**Our Case Number:** ABP-322244-25

**Re:** Proposed works at Galbally Bridge, Moorabbey, County Limerick.  
Mandeville Park, Moorabbey, County Limerick.

**Re:** Proposed works at Galbally Bridge, Moorabbey, County Limerick.  
Mandeville Park, Moorabbey, County Limerick.

Please be advised that the Commission, in accordance with section 177AE(5) of the Planning and Development Act, 2000, as amended, hereby requires you to furnish the following further information.

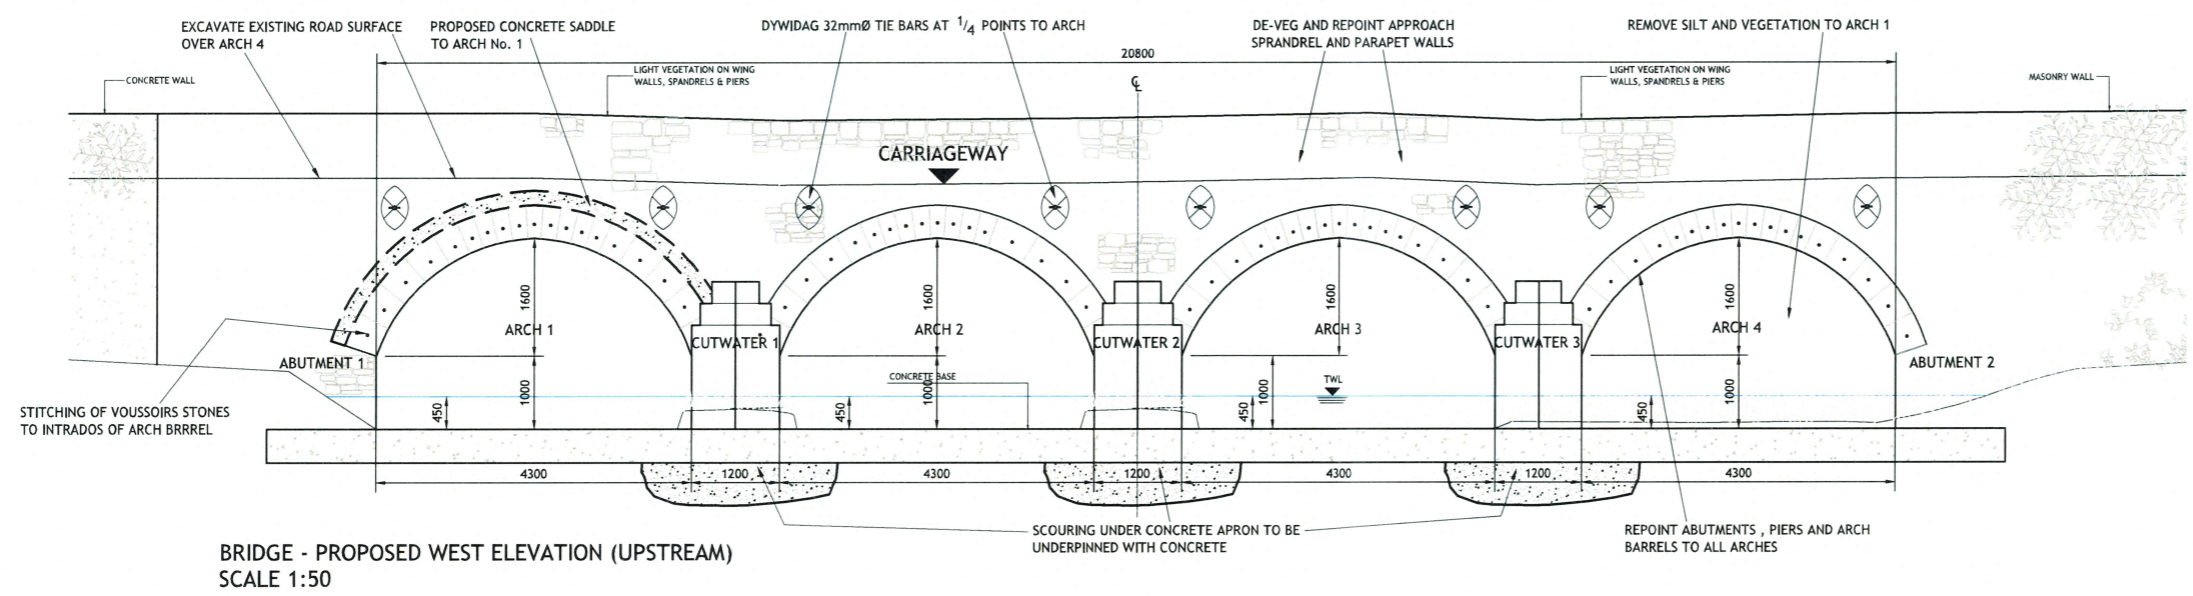
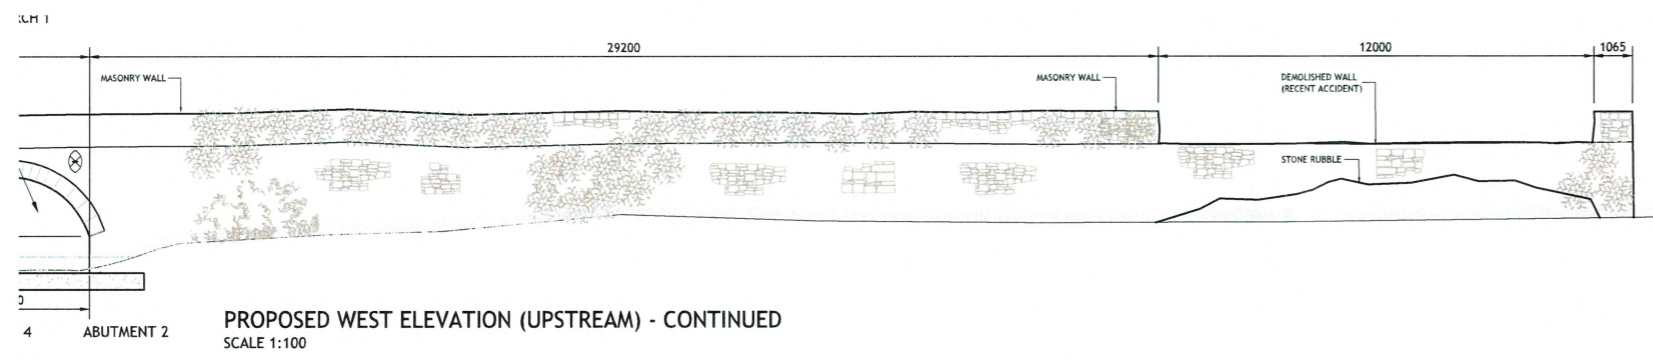
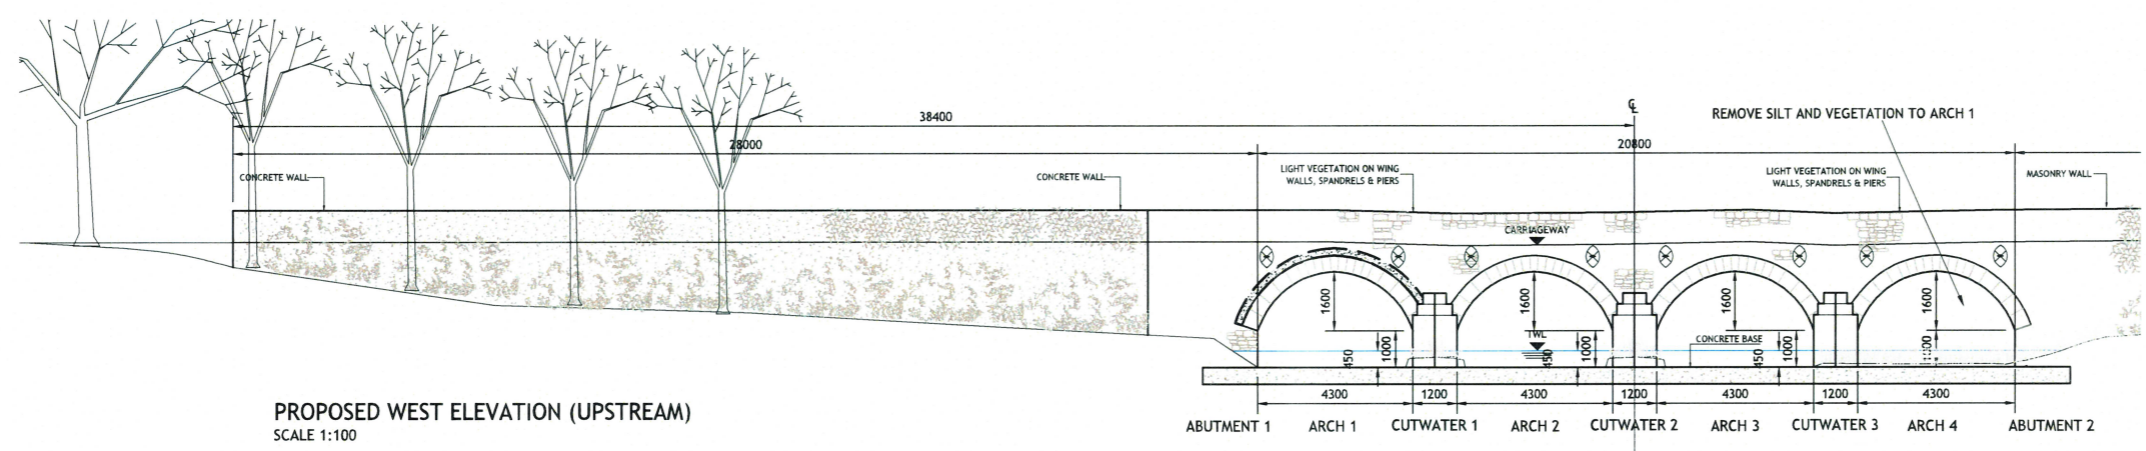
4. The detailed specification of the proposed concrete lintels to improve the flow pattern should be discussed with Inland Fisheries Ireland. Since this would seem to involve a large amount of concrete, it is recommended that only pre-cast and fully cured concrete is used (this has not been specified in the Natura Impact Statement).

EXISTING SECTIONAL PLAN OF ARCH SPANS PIERS & ABUTMENTS
SCALE 1:100

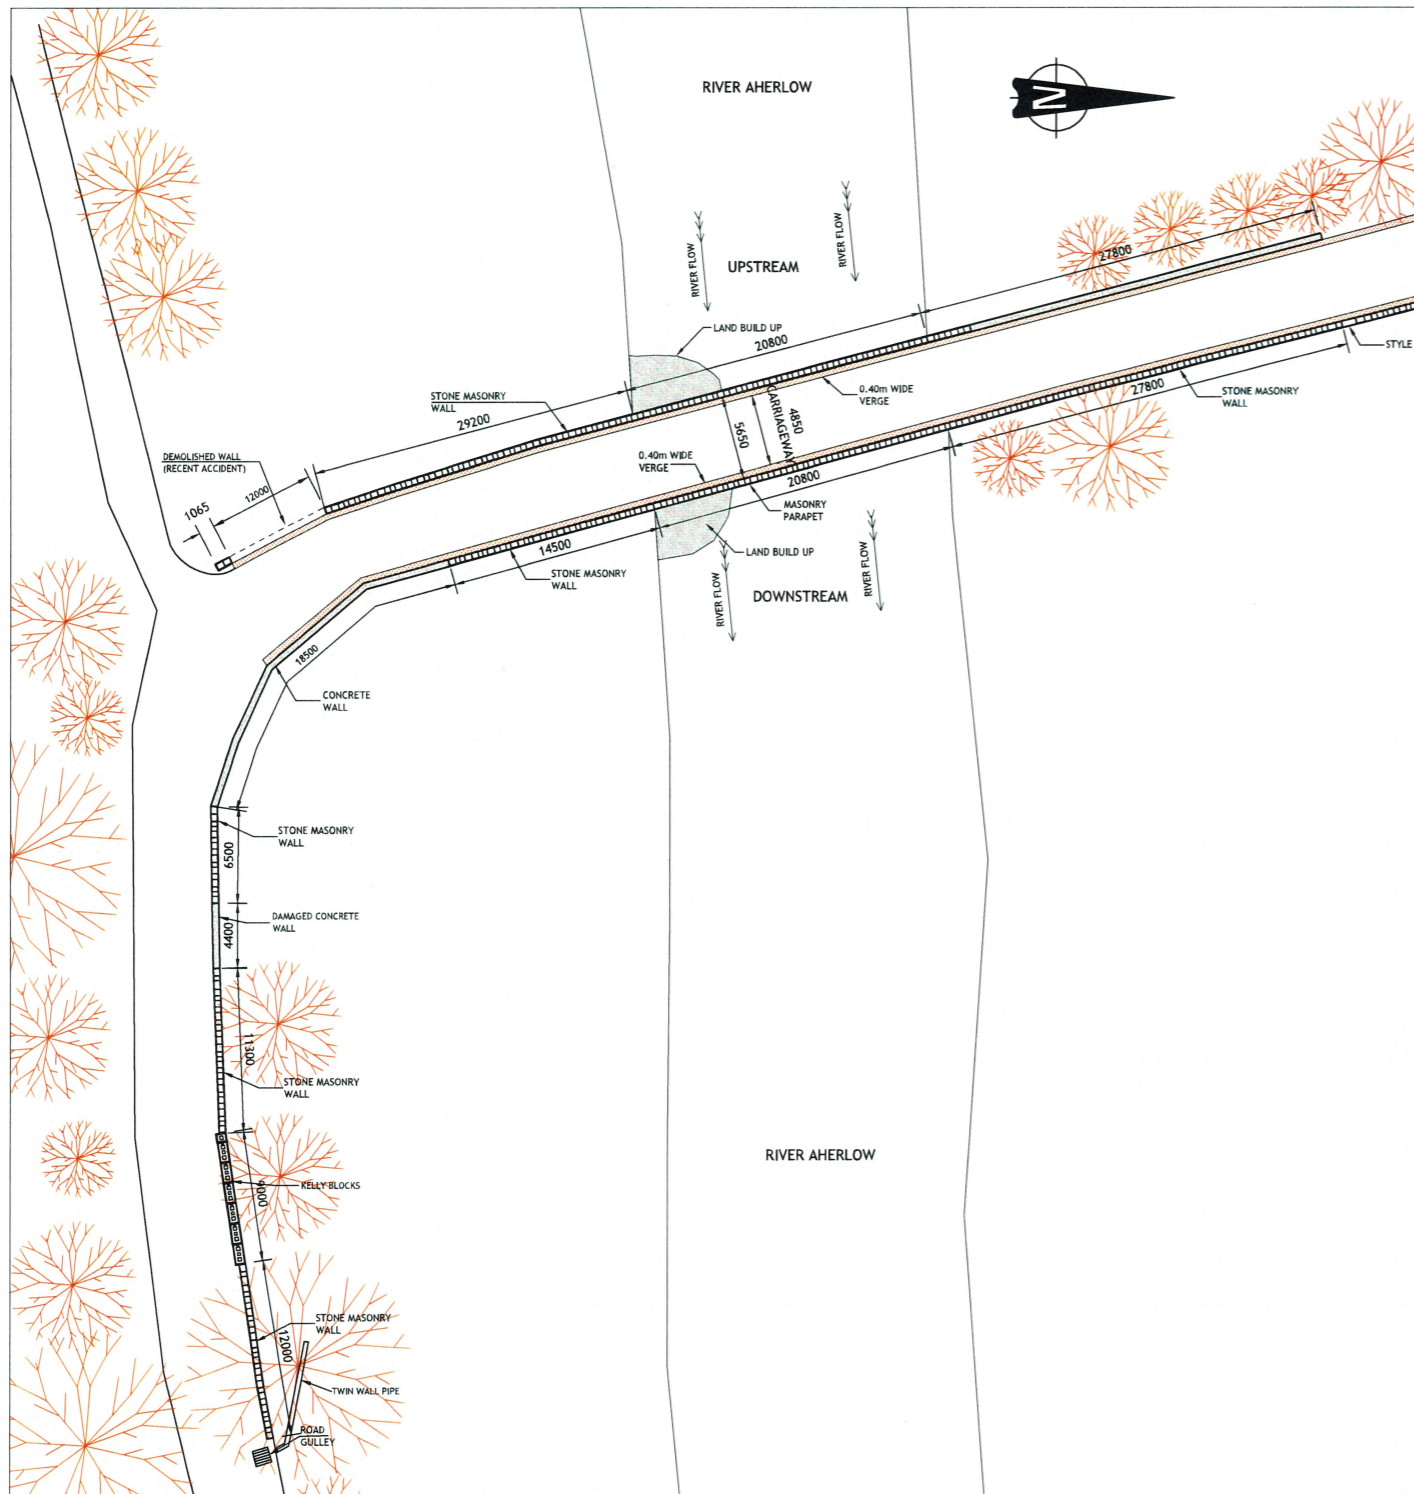
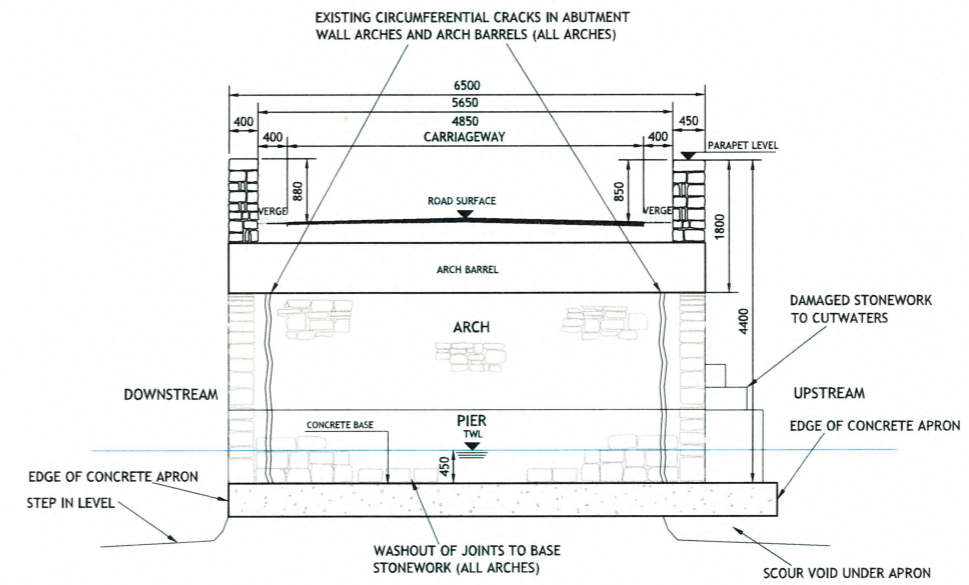
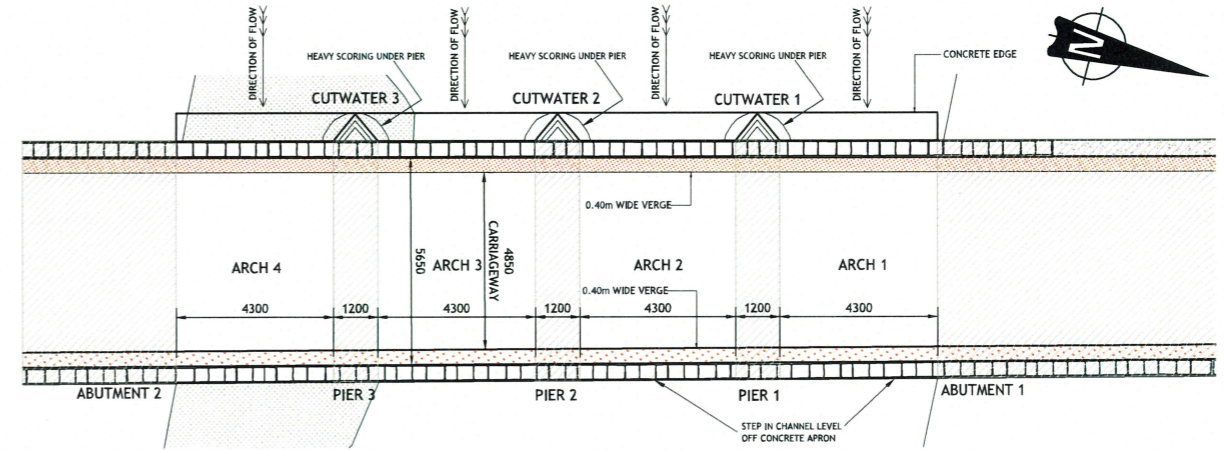
1. It is noted that Galbally Bridge, Moorabbey, Lisvarrinane, Tipperary is listed on the Record of Protected Structures (RPS) under the Tipperary County Development Plan 2022-2028 (RPS Reg. No. TRPS1144), however no architectural heritage impact assessment/survey has been submitted with the application. In addition, it is noted that no method statement has been submitted.

- (a) An Architectural Heritage Impact Assessment Report completed by a suitably accredited architectural heritage professional to include:
  - (i) A full set of survey drawings to a scale of not less than [1:100] to include elevations, plans and sections of the structure;
  - (ii) the recording of the details and current condition;
  - (iii) confirmation that the development will be monitored by a suitably qualified architect with conservation expertise and accreditation; and

- (b) A detailed method statement covering all works proposed to be carried out, including:
  - (i) A full specification, including details of material and methods, to ensure the development is carried out in accordance with the document: "Architectural Heritage Protection – Guidelines for Planning Authorities" (Department of Arts, Heritage and the Gaeltacht, 2011) and details for the protection of (specified features) during the construction works,

- (v) Details to be accompanied by drawings of an appropriate scale of not less than [1:50].
- (c) A detailed construction methodology statement (including the results of detailed structural surveys of the protected structure and all elements to be retained) indicating the means proposed to ensure the protection of the structural stability and fabric of the structure. These details shall include demonstrating the methods proposed to part dismantle and re-instate the bridge structure and to retain other existing facades as proposed, any demolition and excavation arrangements, the proposed foundation system and any proposed underpinning, any structural bracing and support and method of construction.
